# Rezoning Transportation Analysis

Petition Number: 2020-132

General Location Identifier: Tax ID (02911104)

Date	Description
10-22-20	First Review (EL)

SHEET NUMBER: RZ-1.0

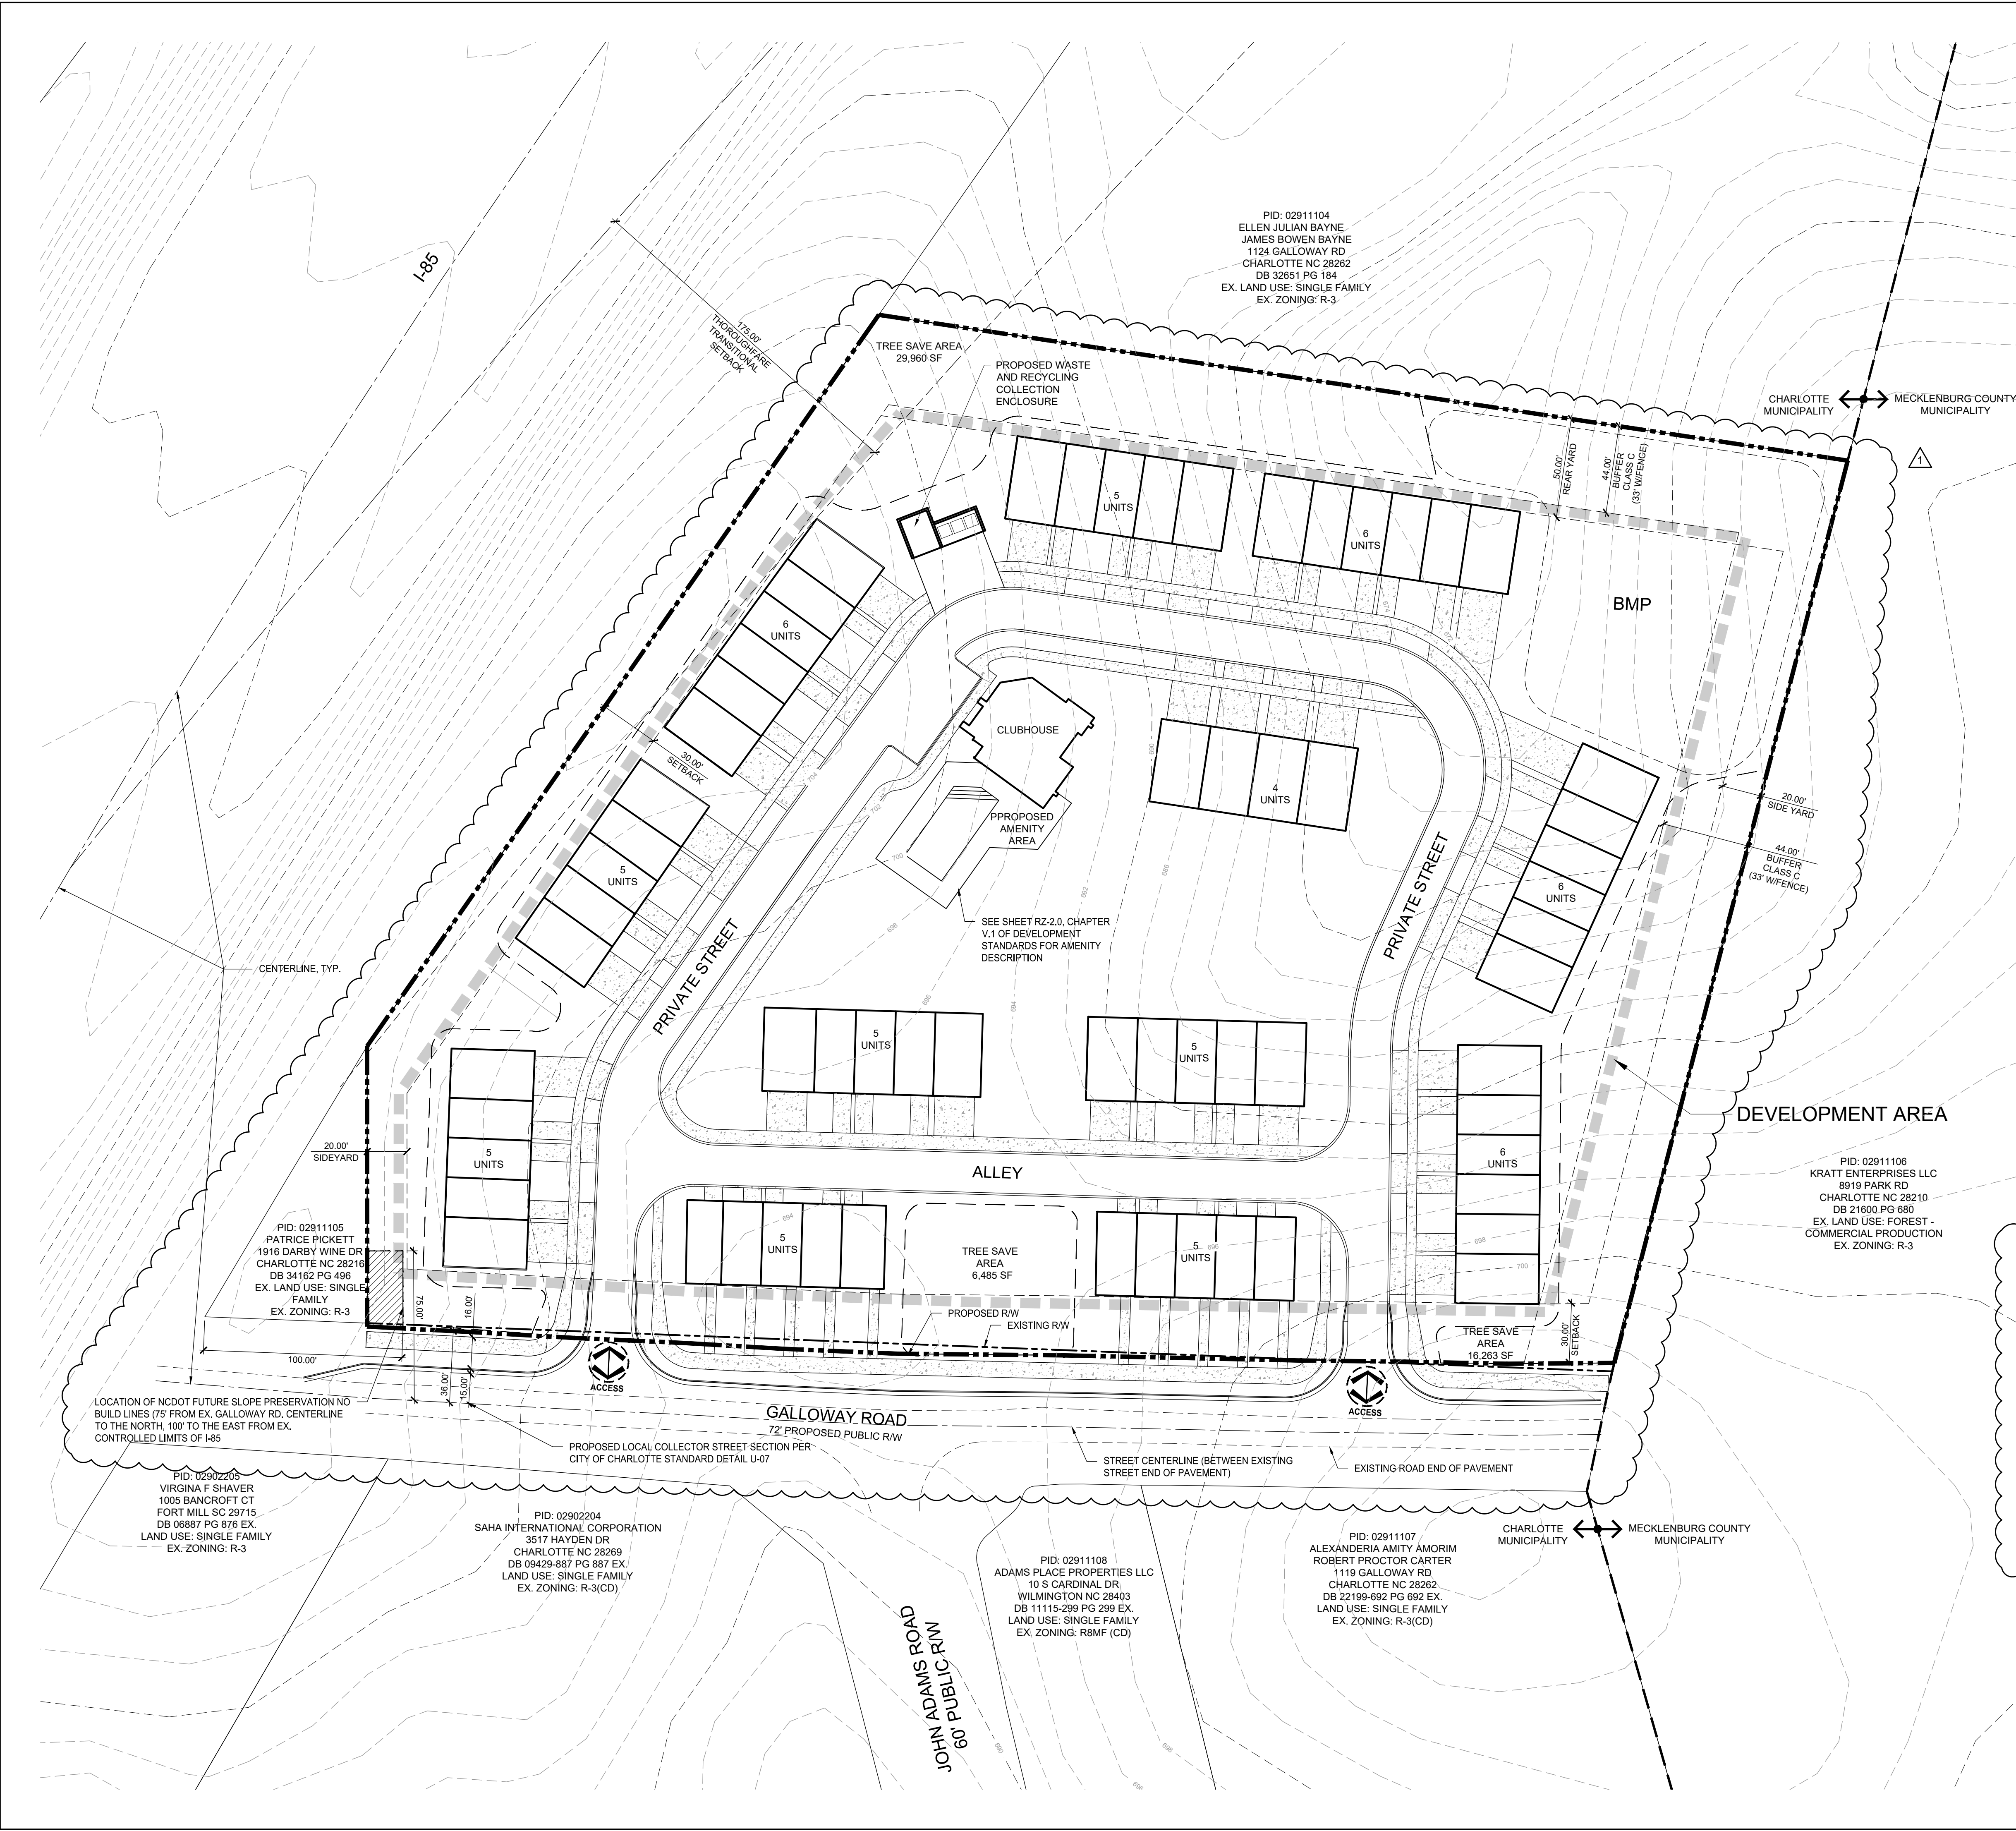
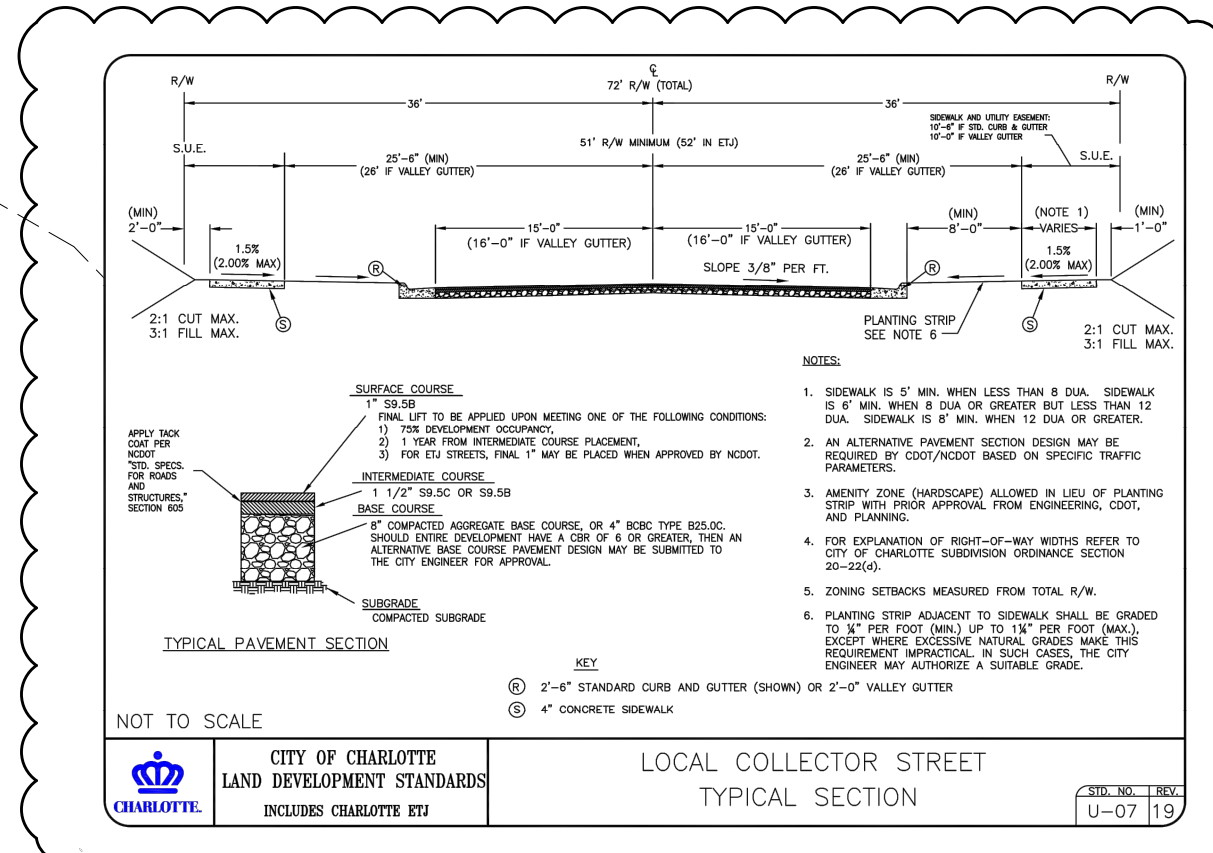
- a. **Galloway Road:** Location of curb and gutter needs to be installed 15-feet from road centerline, to match the collector street cross section that will be constructed within the following approved land development subdivisions: **SDRMF-2018-00082 – Selburn Apartments** and **SDRMF-2018-00071 – Galloway Park**. Refer to Charlotte Land Development Standards Manual (CLDSM) std. no. U-07 – *Local Collector Street Typical Section*. CDOT requests the complete curb and pavement section to be constructed, due to the existing condition of Galloway Road.

Label and dimension curb and gutter from the centerline for each road.

3. Revise site plan and conditional note(s) to commit to dedicate 36-feet of right-of-way from the road centerline, labeled and dimensioned from the road centerline.
4. Revise site plan and conditional note(s) to commit to construct an 8-foot planting strip, and 8-foot sidewalk on Galloway Road as per Chapter 19 / Chapter 20. Label and dimension both items from the back of curb and gutter and road centerline.
5. The proposed dwelling units exceeds 12 per acre. Per Chapter 20 Subdivision ordinance, site plan and conditional note(s) revisions are needed to commit to construct an 8-foot planting strip, and 8-foot sidewalk along Galloway Road. The wider sidewalk also meets the Charlotte WALKS Policy.

6. Revise the site plan and conditional note(s) to commit to reserve 100-feet to the east of the existing controlled access limits of I-85 and 75-feet to the north of the existing Galloway Road centerline to establish a slope preservation for a future I-85 bridge crossing. Refer to the site plan and conditional notes within rezoning petitions 2016-139 and 2017-150 for reference.
